**National Grid – Yorkshire Green Project  
Procedural Deadline 3**

**Post-hearing submissions, including written summaries of oral submissions to the hearings and any documents requested by the ExA.**

## **Appendix B – Response to Action Point 18**

### **DASSI-REP2-049**

Figure 15: Shipton Cable Sealing End Compounds Illustration

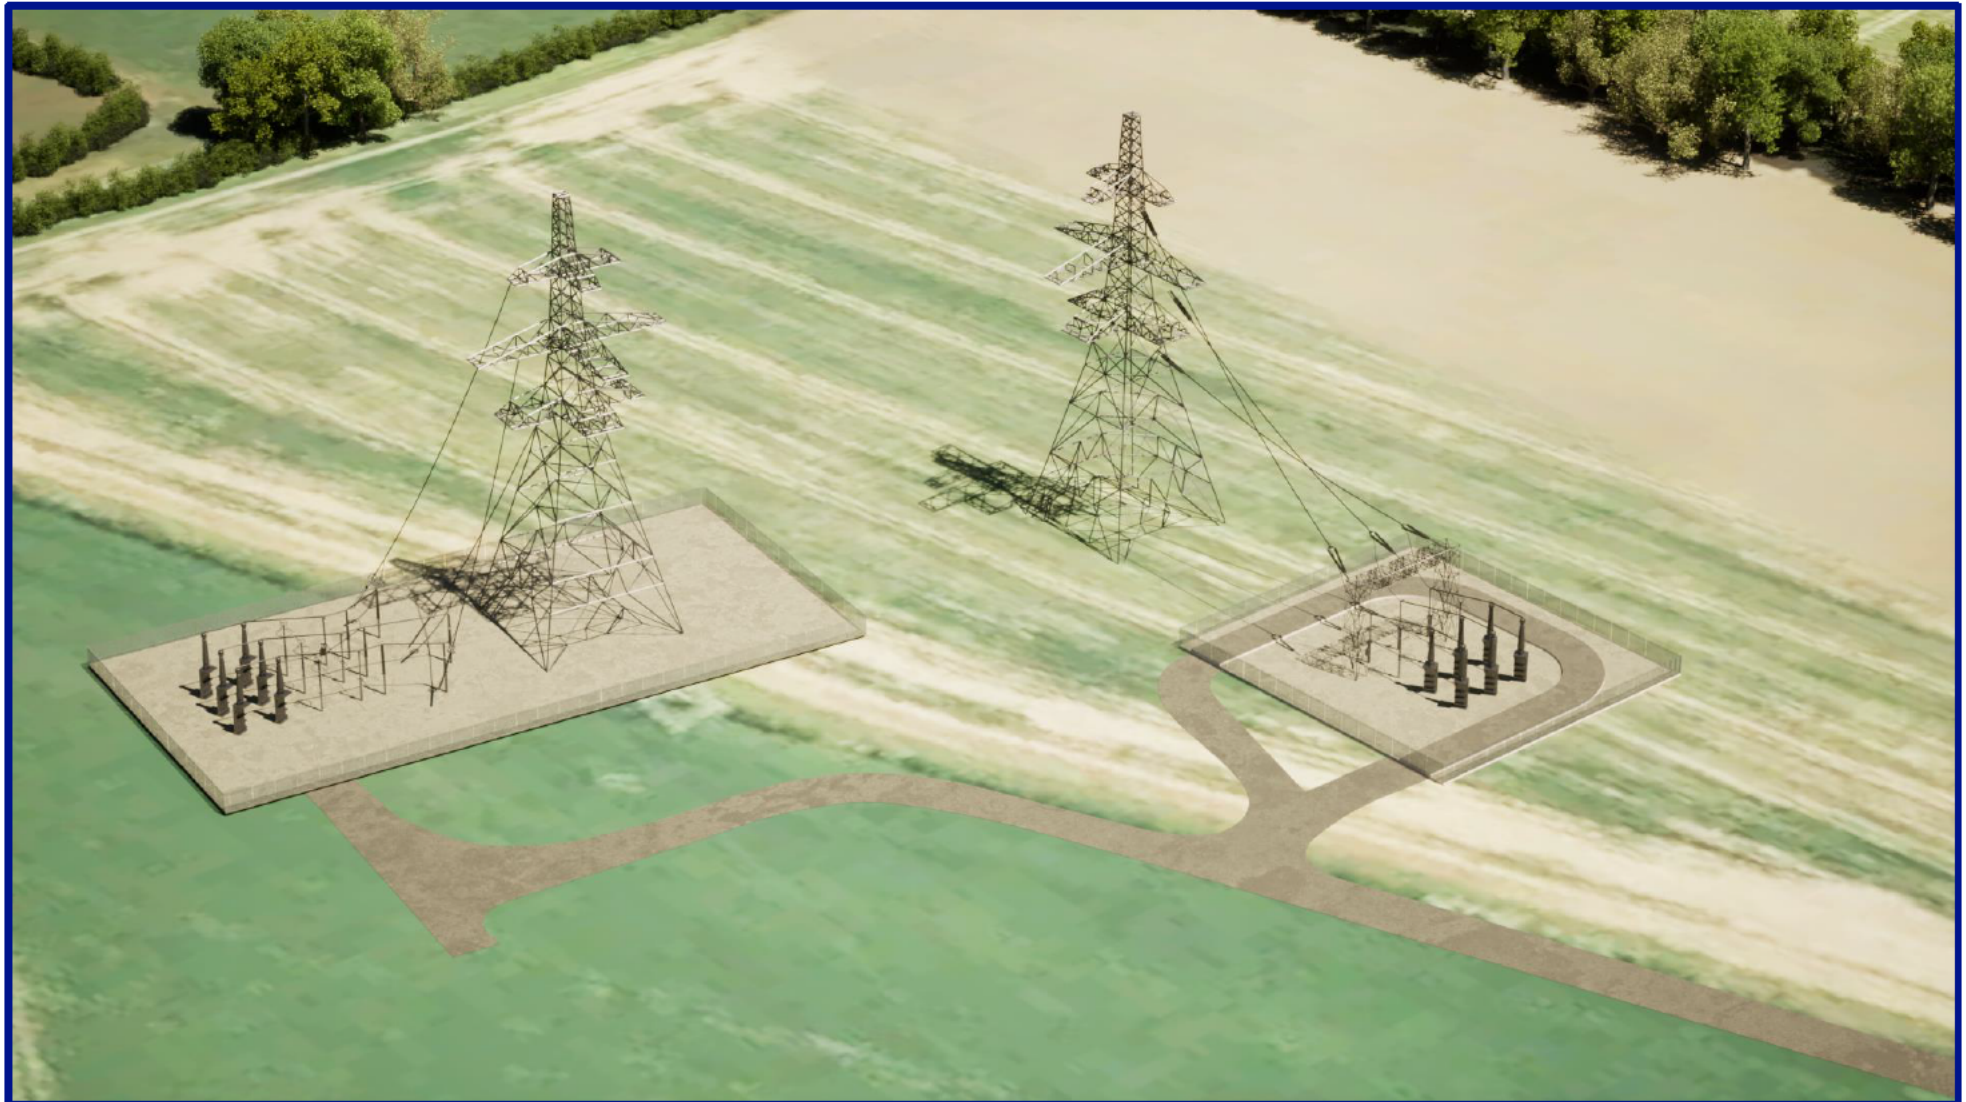
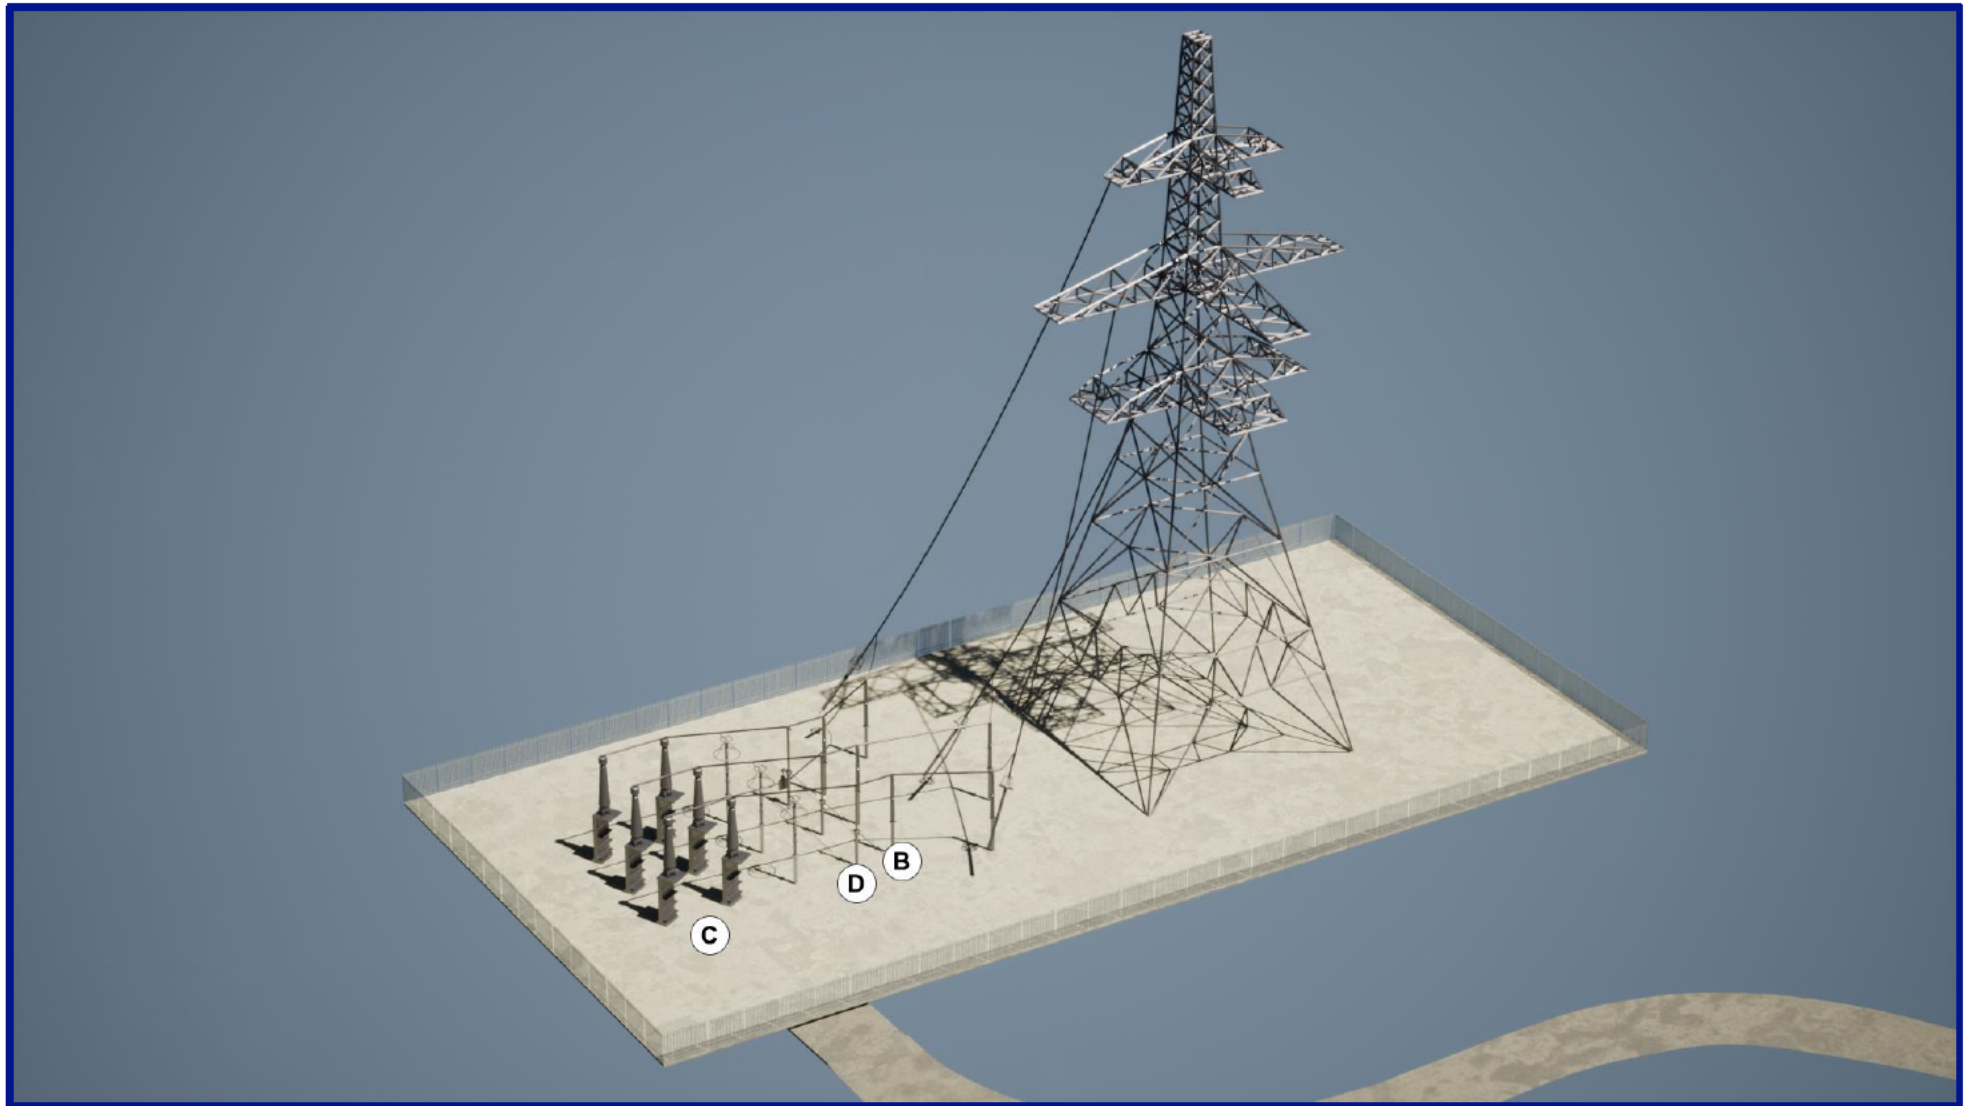
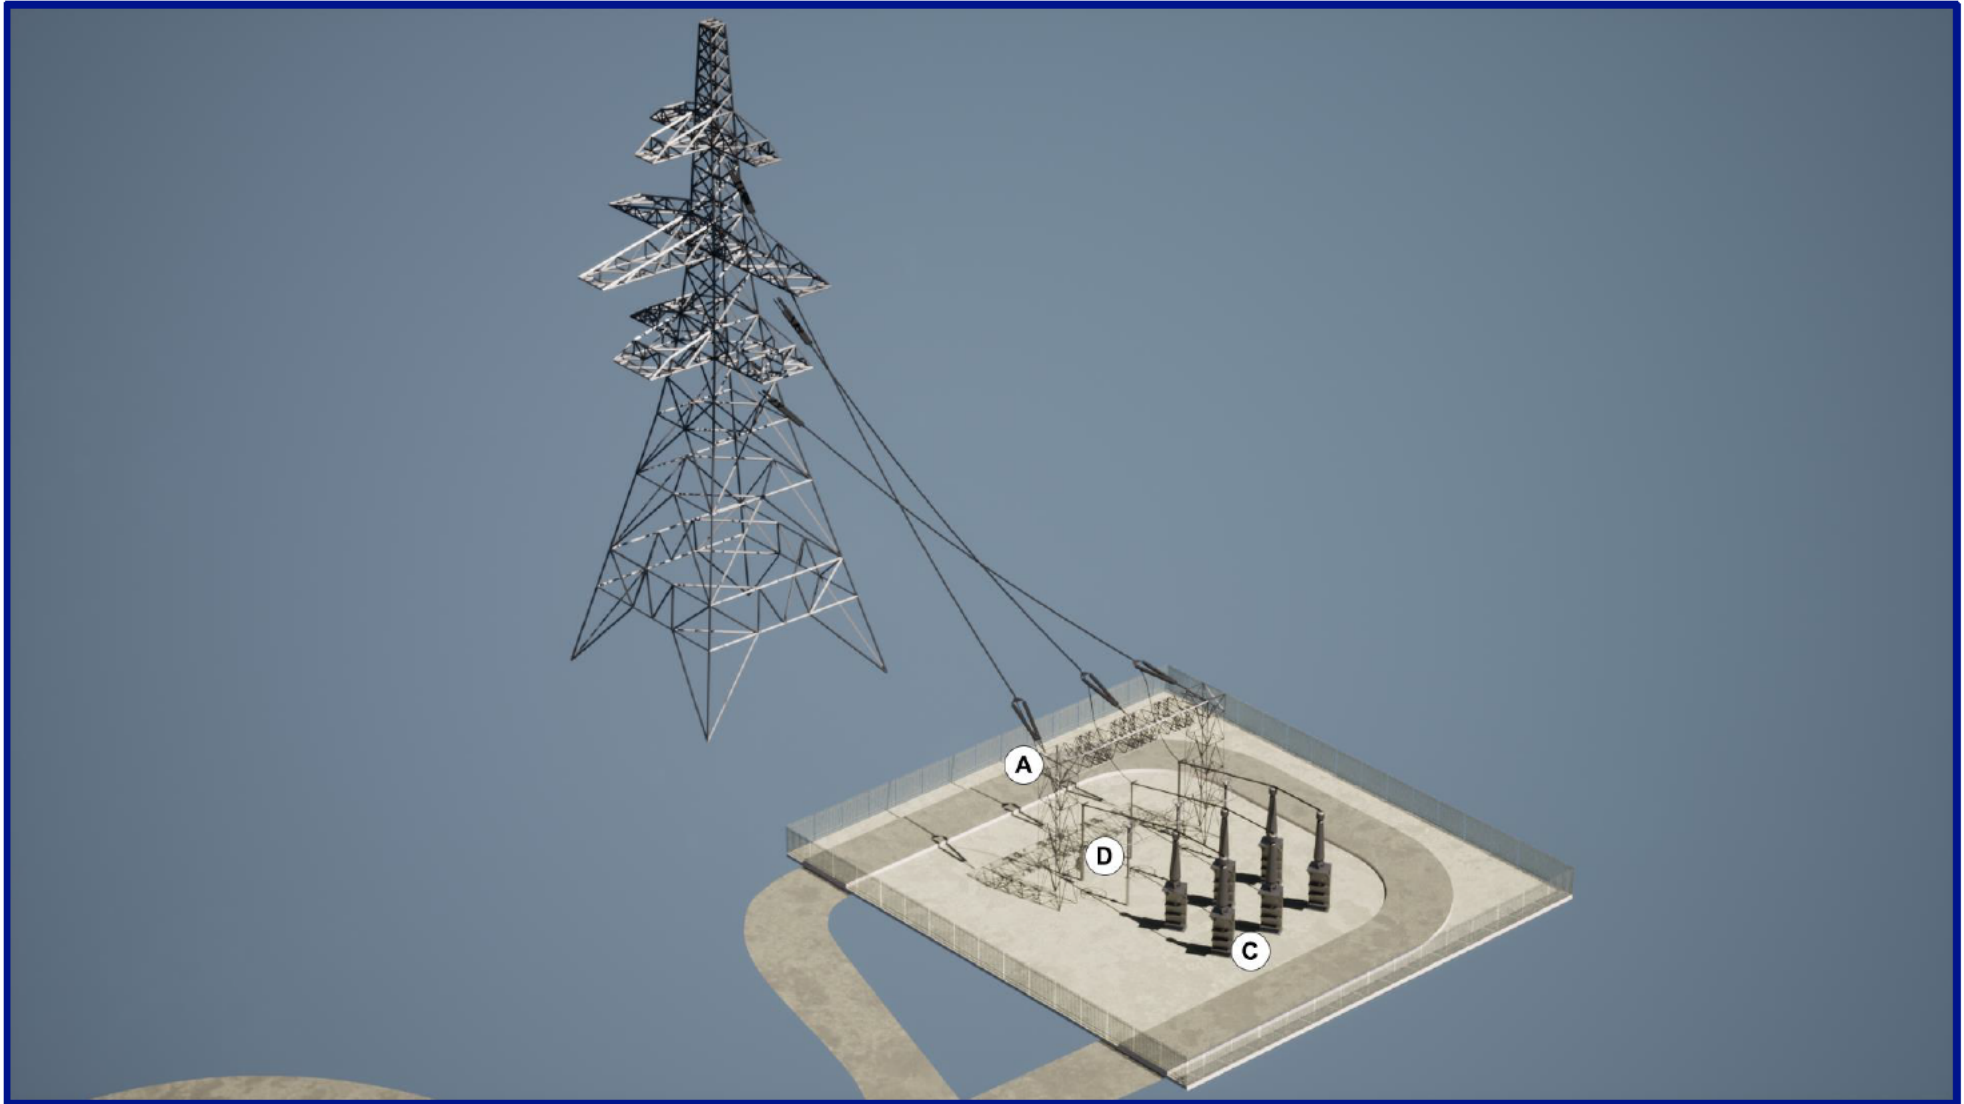
This should include appropriate options for different locations to be agreed under requirement 18 (provided it is acceptable to highways). Different options are mentioned in the DASSI. However, the suggestions and examples are not in accordance with the Horlock Rules. For example, the illustration of the CSE with Anchor Blocks at Figure 5. in Kingswell in the DASSI would have much less impact and blend in better with the surrounding green landscape if the fencing was green and the surfacing within the site was a more muted earth colour. This principle would also apply at all the CSE compounds as well as the substations. The white/grey aggregate mix can be a very startling contrast with the surrounding green/brown rural landscape. Aggregate stone can be a mix of more browns with grey and the maintenance characteristics would be unaffected.

Figure 21: Red Brick (Source: Ammaari Stones)

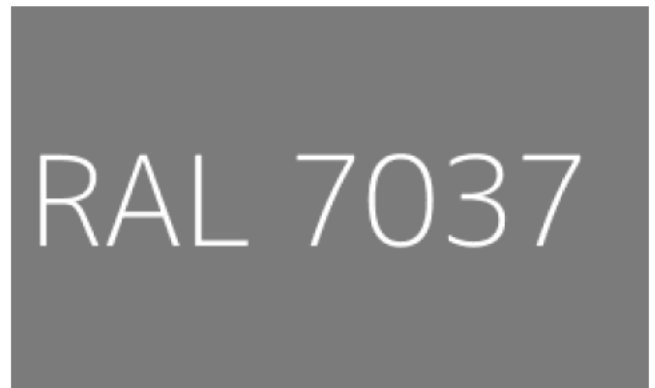
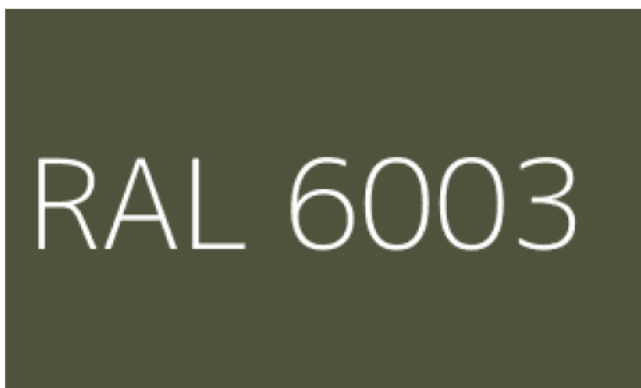
A range of illustrations are provided with different building material options including red brick or cladding in green, grey and the supporting text indicates there is scope for variation within the range. This is generally acceptable provided the most appropriate choice for the individual location can be agreed. Eg. Overton Figures 25, 26, 27 & 28 and Monk Fryston Figures 35, 36, 37 and 38. However, it is unclear which buildings are meant in para 4.1.54 or what is meant by 'prefabricated buildings'. No detail is provided of their intended colour or finish. Para 4.1.46 indicates the existing workshop relocated will remain in white. It is unclear which building this is, what the white material is or where it would be re-located. However, a white building could stand out in sharp contrast to the muted colours of the surrounding rural landscape.

Further options to reflect the principles above should therefore be included in the DASSI and reflected in the wording of Requirement 18 a indicated in the tracked changes shown below.
